Subject: Taylor Wimpey Reserved Matters Application - AL/102/17/RES

Re: AL/102/17/RES - Reserved Matters Planning Application Land at Nyton Road and Northfields Lane Westergate - AL/102/17/RES put forward by Taylor Wimpey.

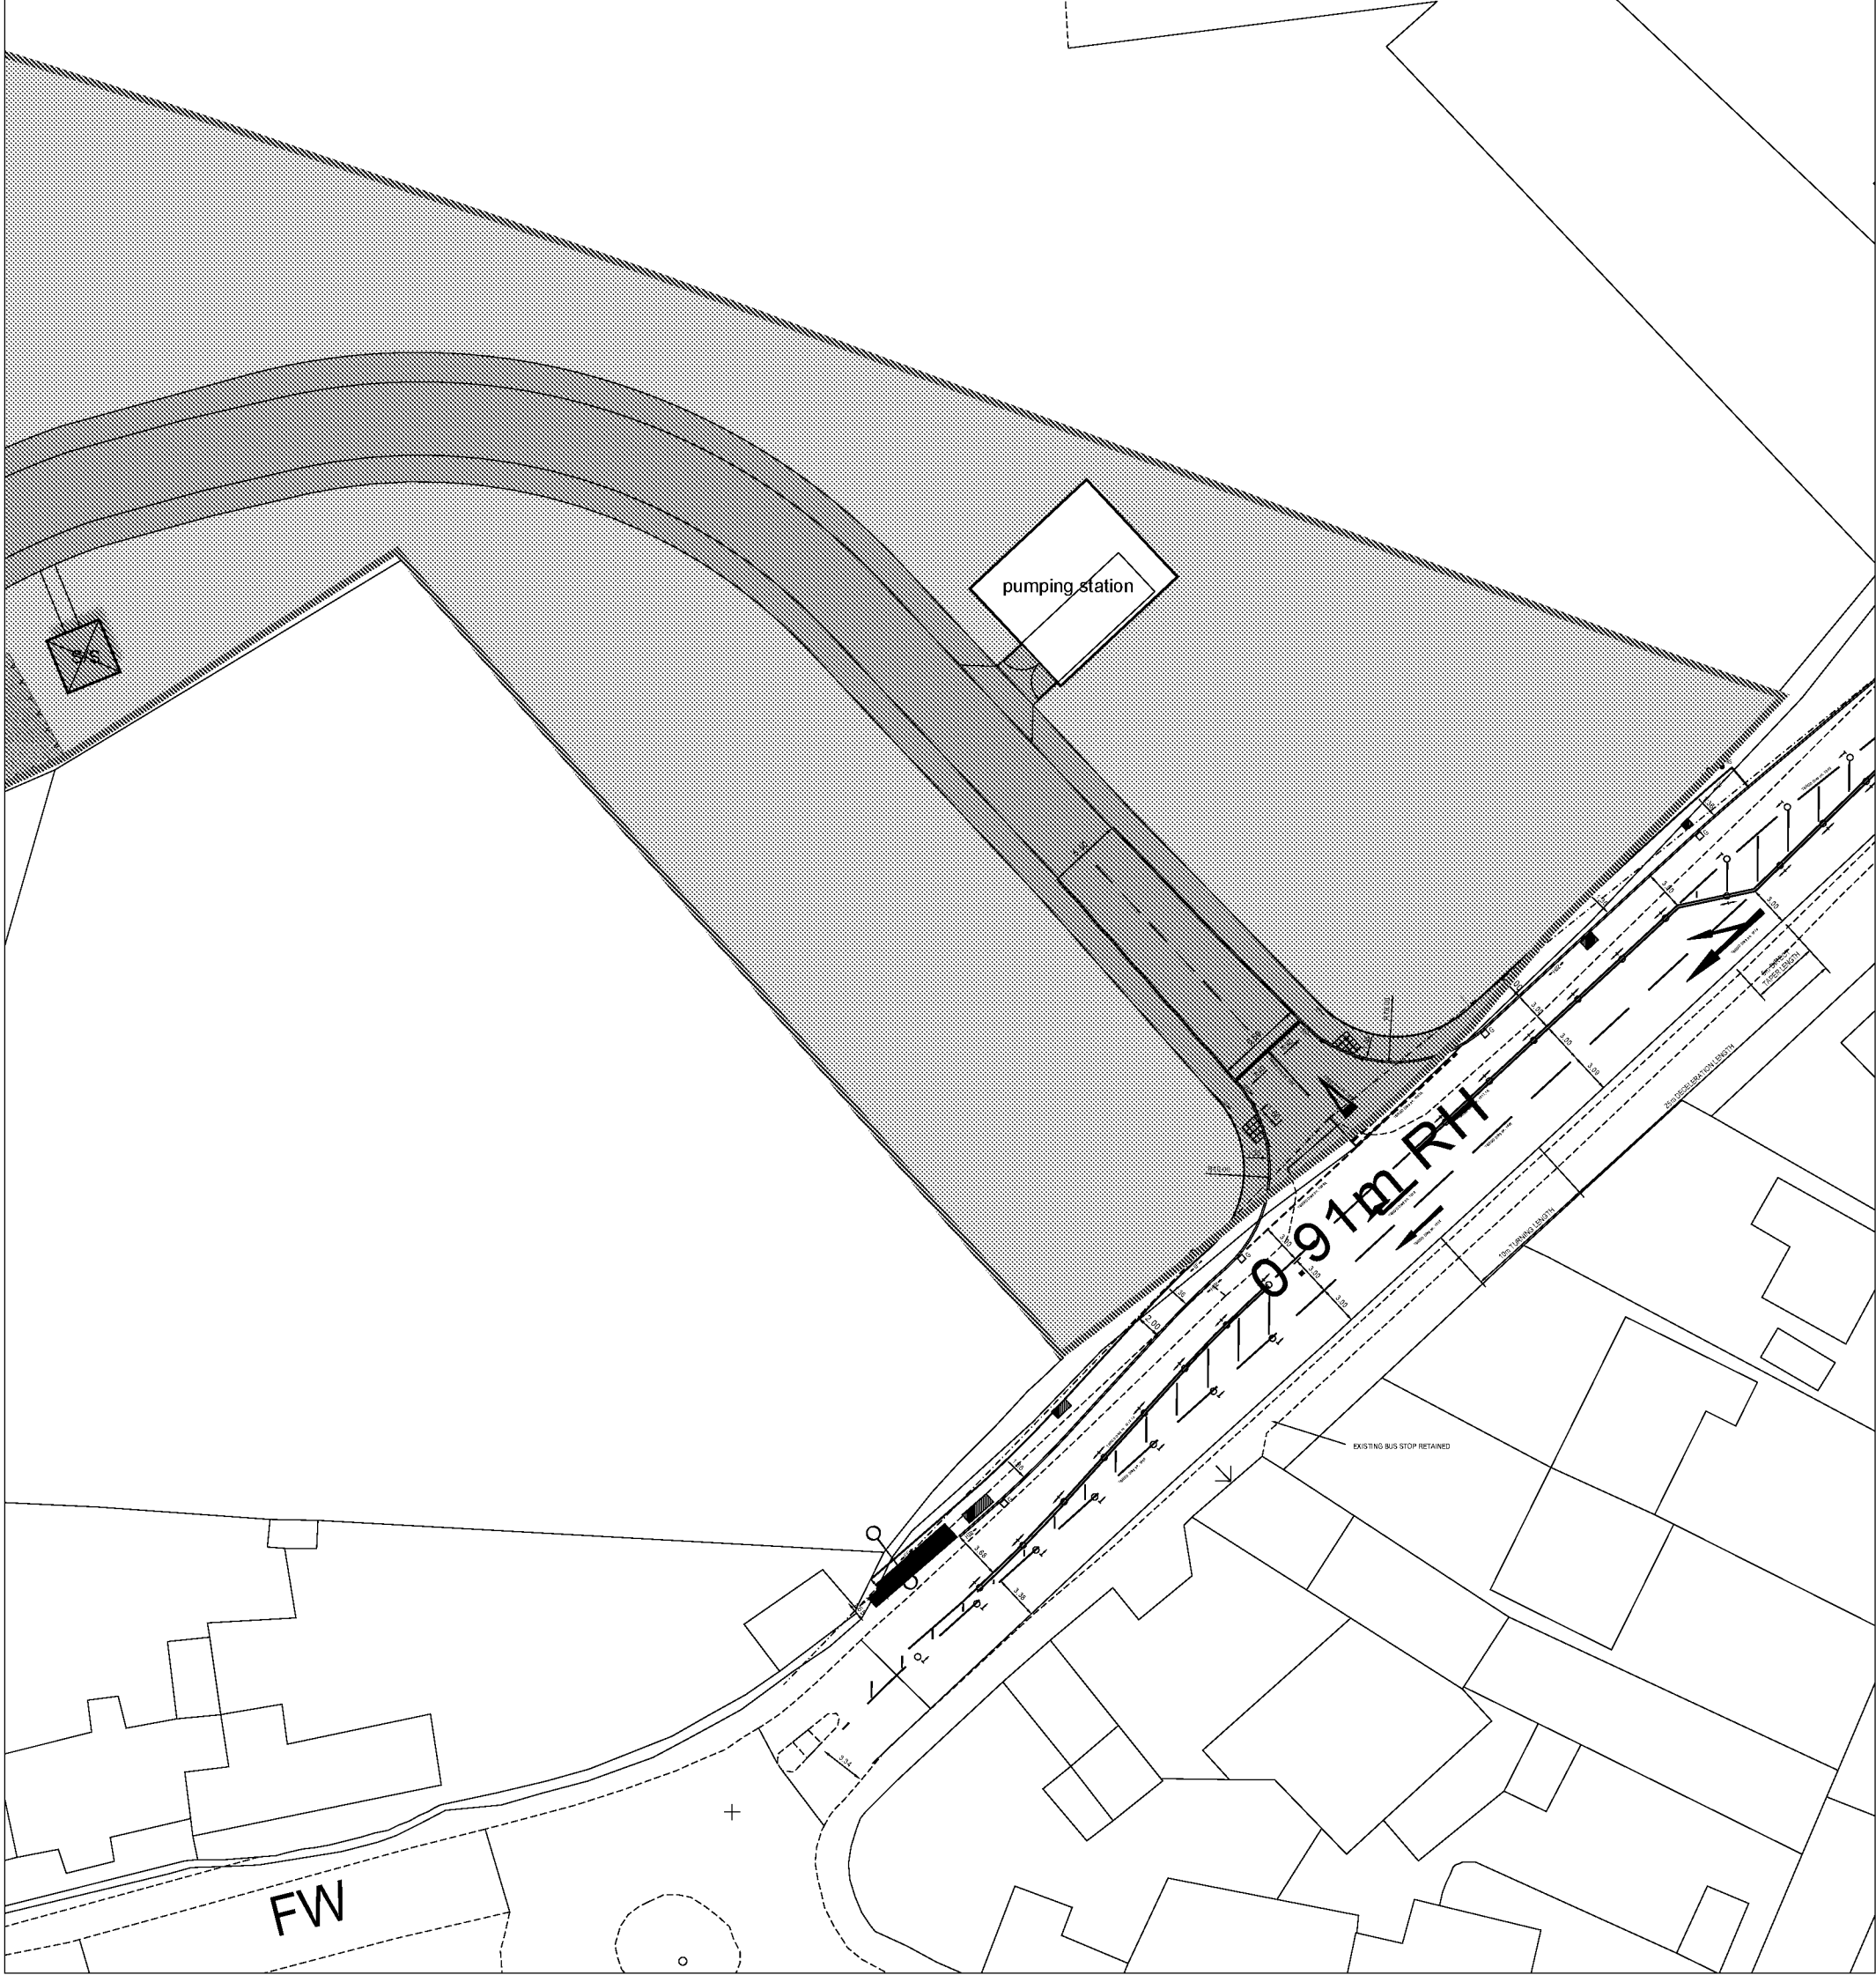
From the plans of the Reserved matters application (and Taylor Wimpey newsletter) it is clear that the semi-detached houses of Plots 21 and 22 are set at an angle that would enable potential residents to see straight into our bedroom and kitchen (we have floor to ceiling windows for bedroom and kitchen) and of course we would be able to view directly into the rear windows of plots 21 and 22 and their neighbours.

Plots 20, 19, 18 and 17 also appear to have uninterrupted views into our house. It is extremely disappointing that Taylor Wimpey have not responded to my email or my telephone call asking specifically about what will be done to address these privacy issues, particularly regarding Plots 21 and 22.

Screening using trees of 20 feet high would be needed along the development site boundary in line of sight with our property and also fencing to demarcate the boundary. However, Taylor Wimpey have offered no reassurances or advised on how they will follow the Inspectors advice in minimising the impact of this development on our family.
